7 May 2015

**CORMORANT ROAD (B63): CAR WASH FACILITY (DA6988), 130 CORMORANT ROAD,
KOORAGANG – NOTICE OF EXHIBITION**

CAR WASH SITE PLAN

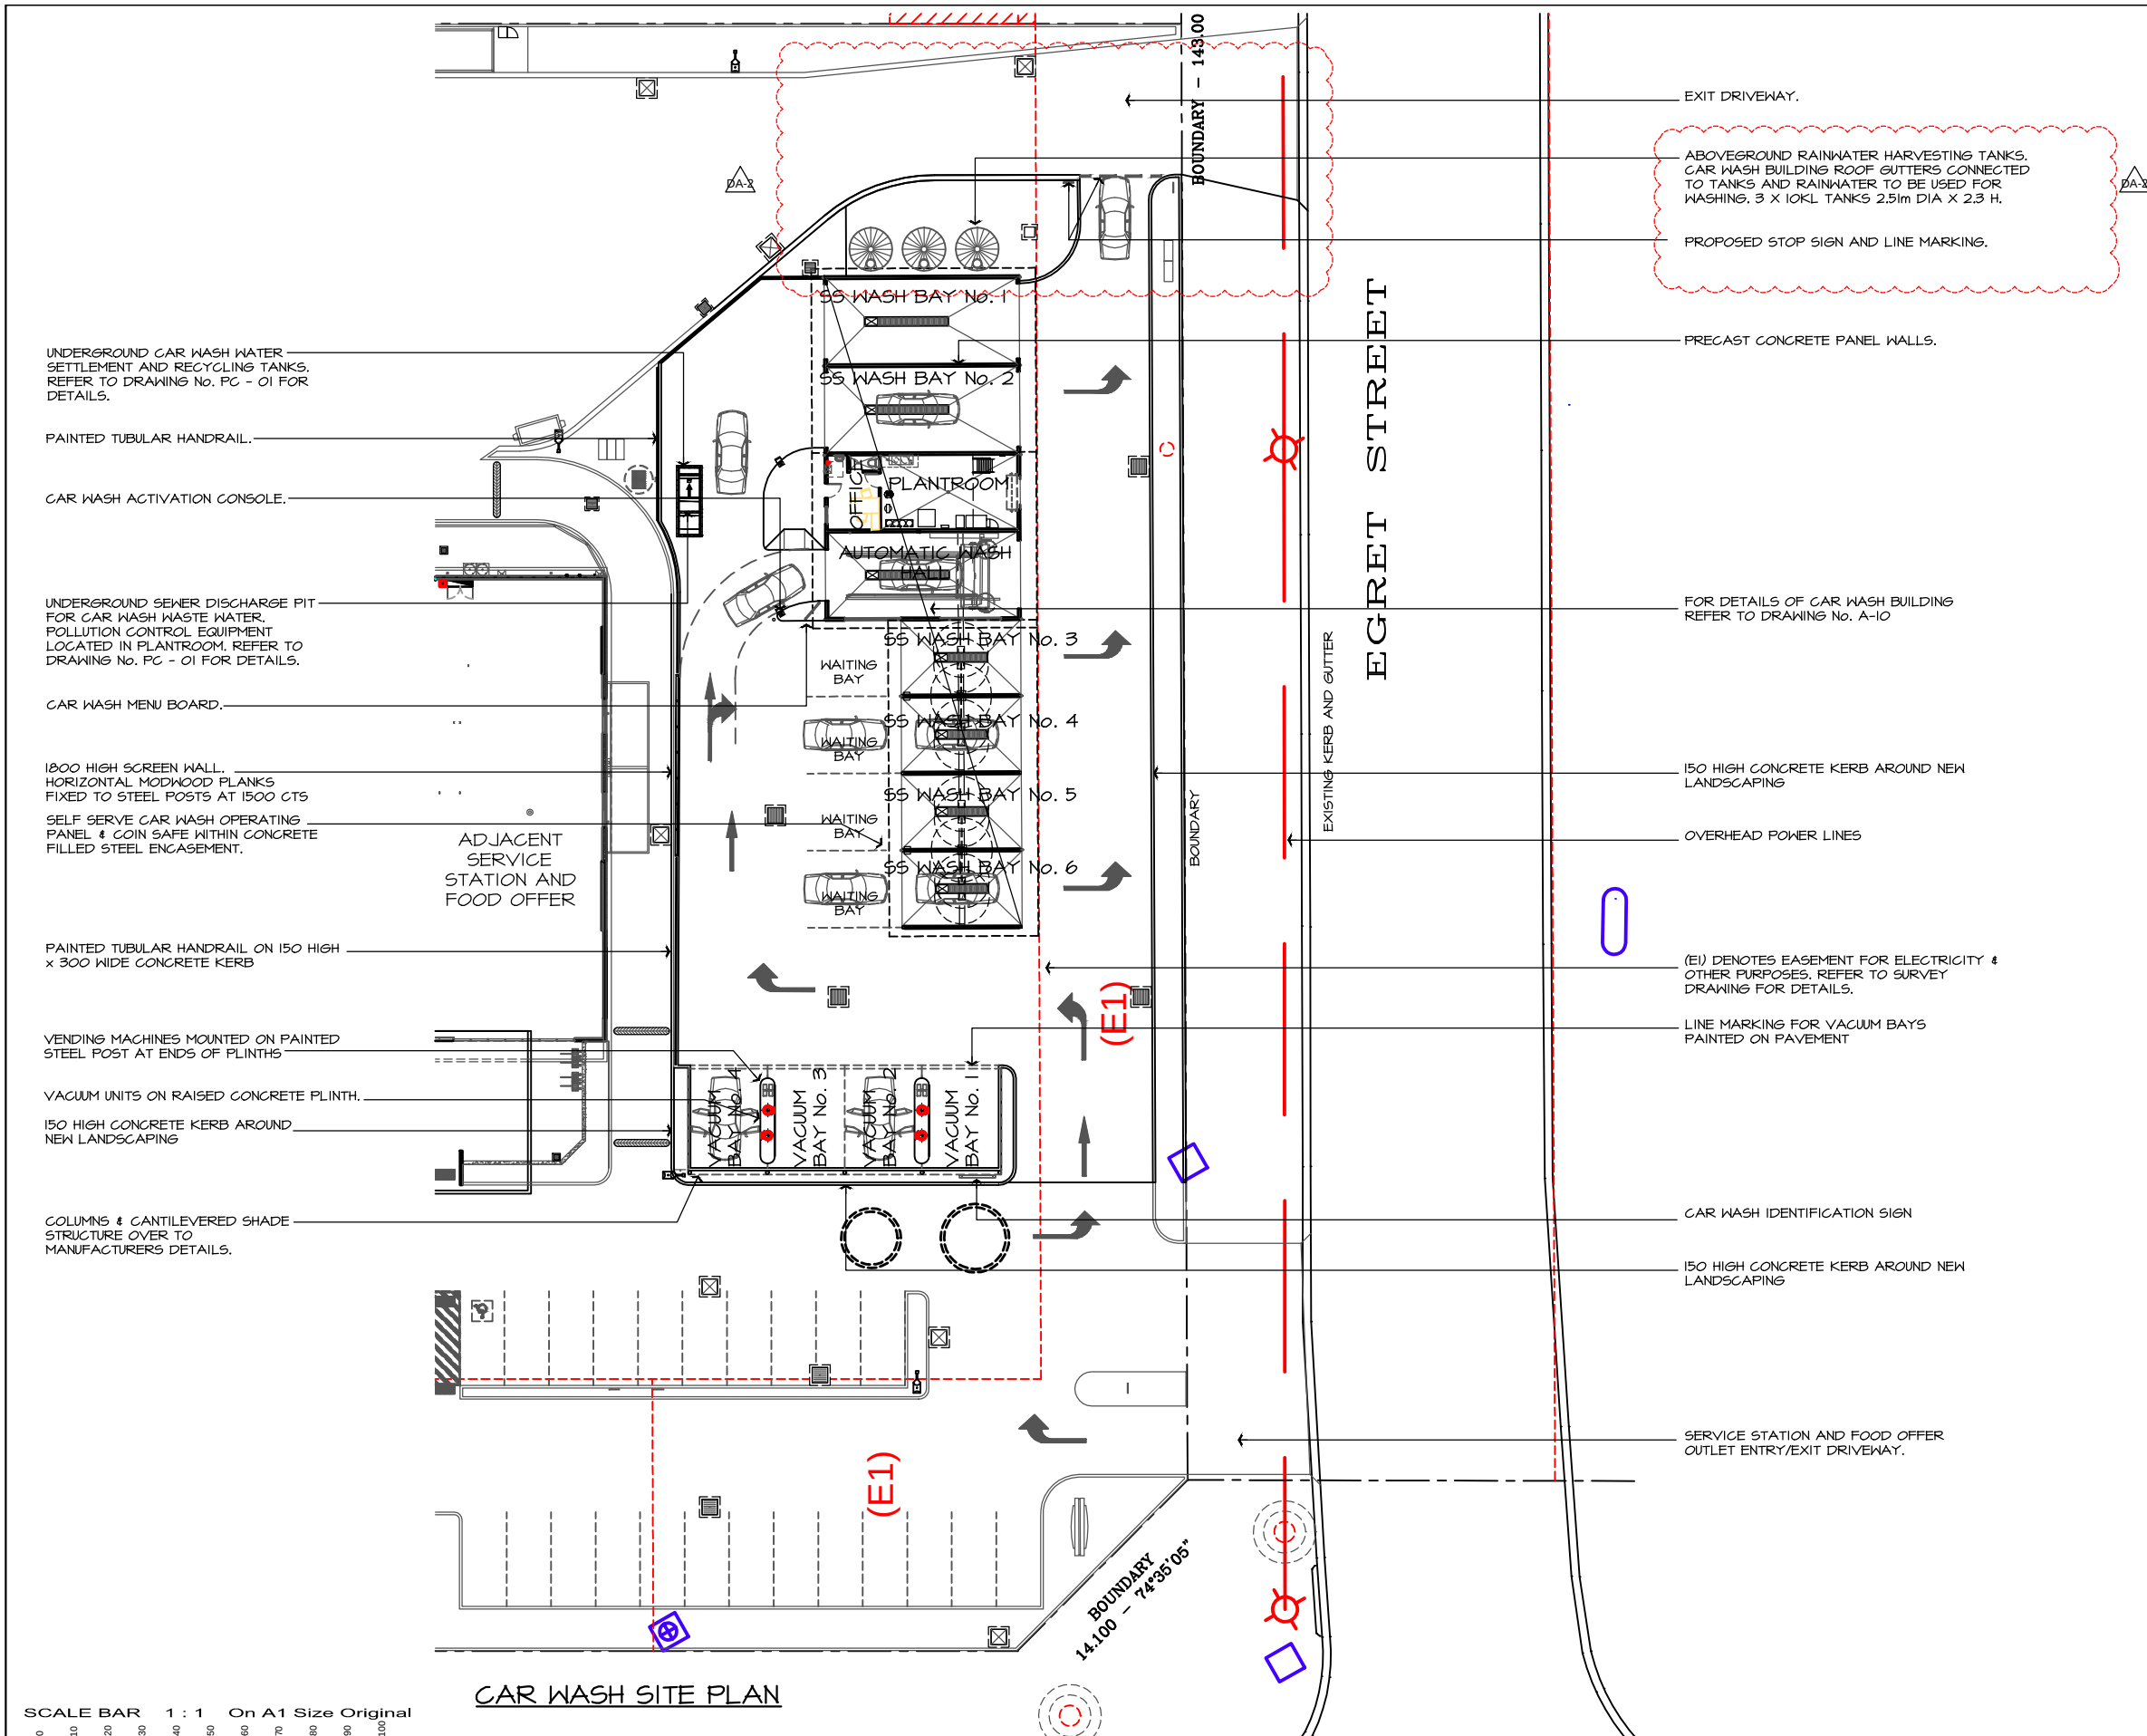
- Council should ensure that the traffic entering the car wash off Egret Street does not get held up and congested by vehicles exiting the service station leading to vehicles being stopped on the road.
- All matters relating to internal arrangements on-site such as traffic / pedestrian management, manoeuvring of service vehicles and provision for people with disabilities are matters for Council to determine.
- Discharged stormwater from the development shall not exceed the capacity of the Cormorant Road stormwater drainage system. Council shall ensure that drainage from the site is catered for appropriately and should advise Roads and Maritime of any adjustments to the existing system that are required prior to final approval of the development.
